**PAVEMENT DESIGN REPORT
SADDLEHORN RANCH
FILING 2
EL PASO COUNTY, COLORADO**

Prepared for:
**Gorilla Capital Colorado Saddlehorn Ranch, LLC
1345 High Street
Eugene, OR 97401**

February 15, 2024

**SITE AND EXPLORATION PLAN**  
SADDLEHORN RANCH, FILING 2  
GORILLA CAPITAL CO.

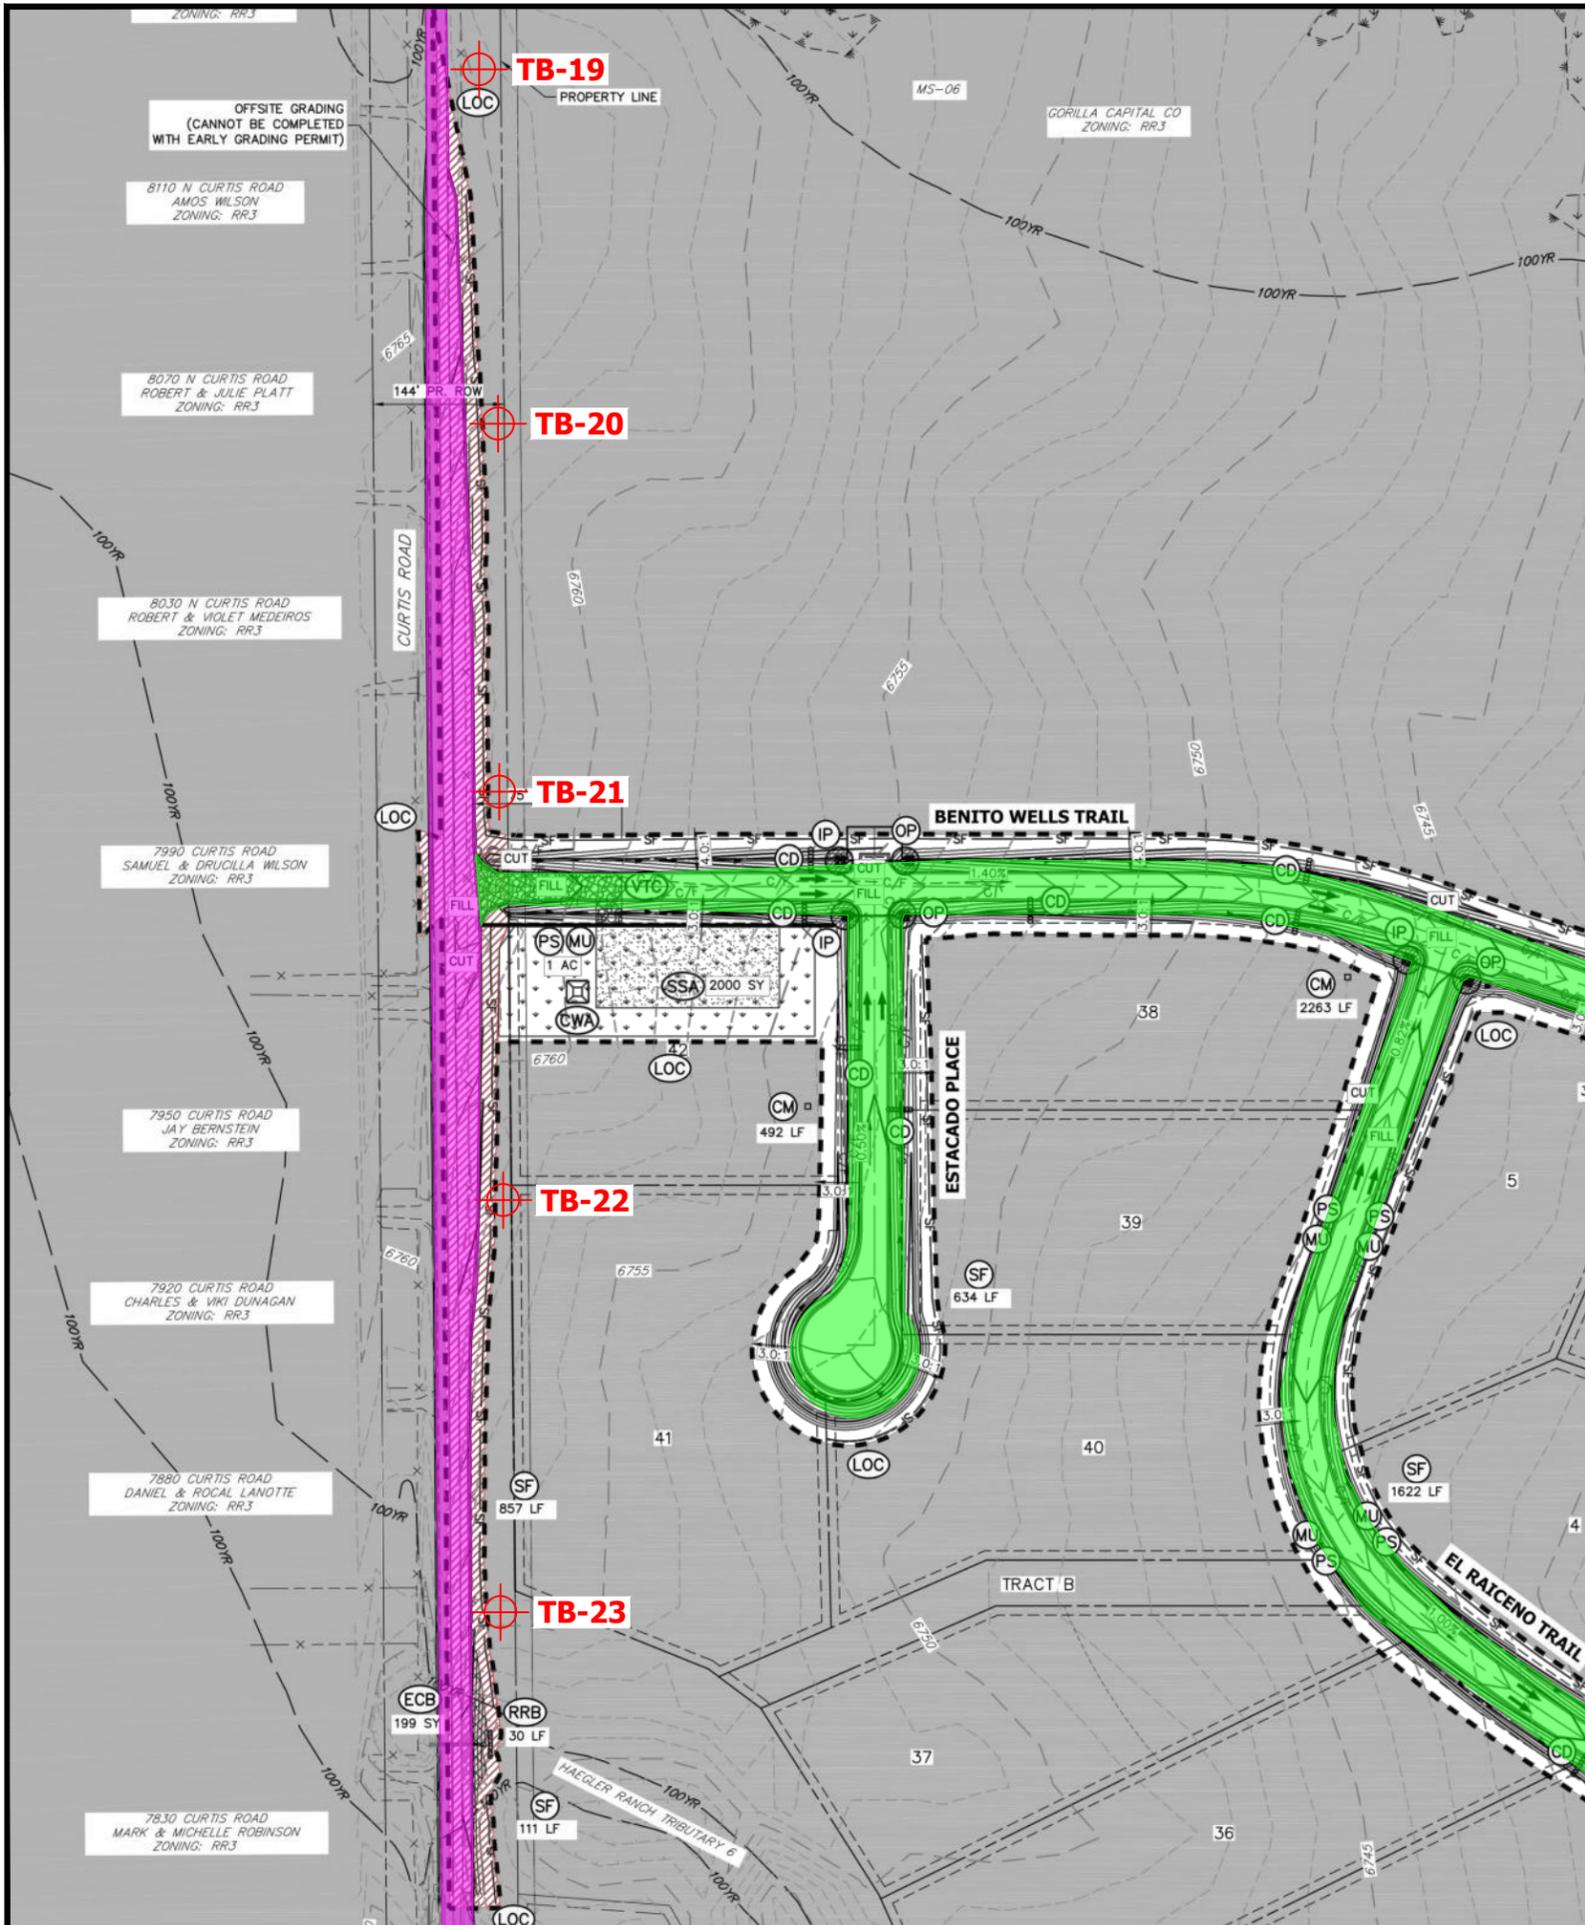
Per Saddlehorn Filing 2 traffic study, the classification for Curtis Road is a principal arterial. Revise to provide pavement recommendation for a principal arterial cross section.

SITE AND EXPLORATION PLAN
 SADDLEHORN RANCH, FILING 2
 GORILLA CAPITAL CO.

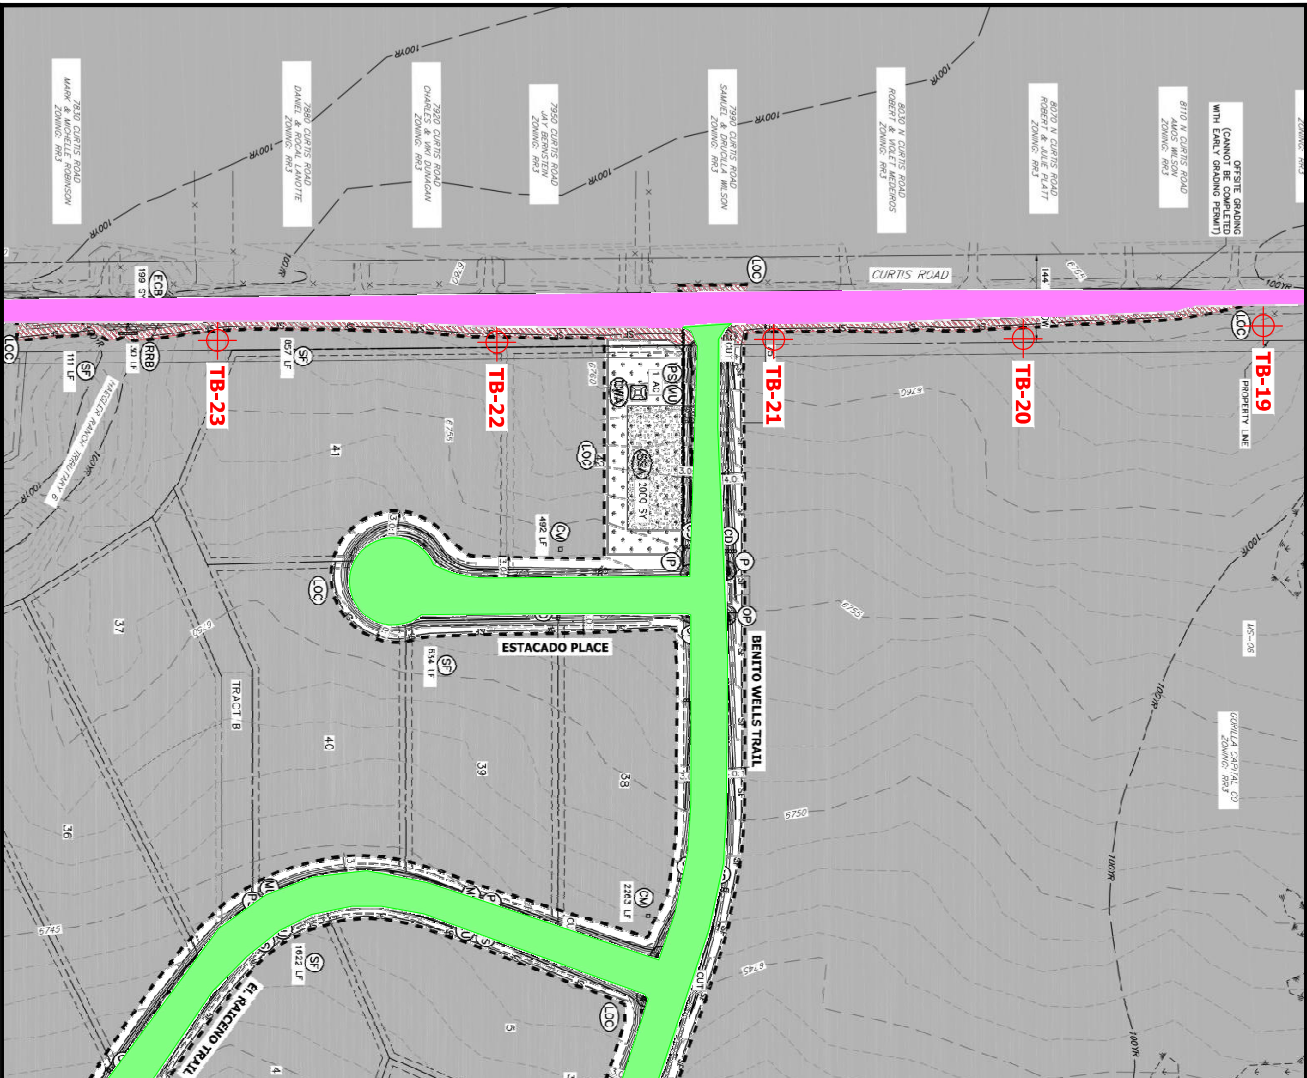
Per Saddlehorn Filing 2 traffic study, the classification for Curtis Road is a principal arterial. Revise to provide pavement recommendation for a principal arterial cross section.
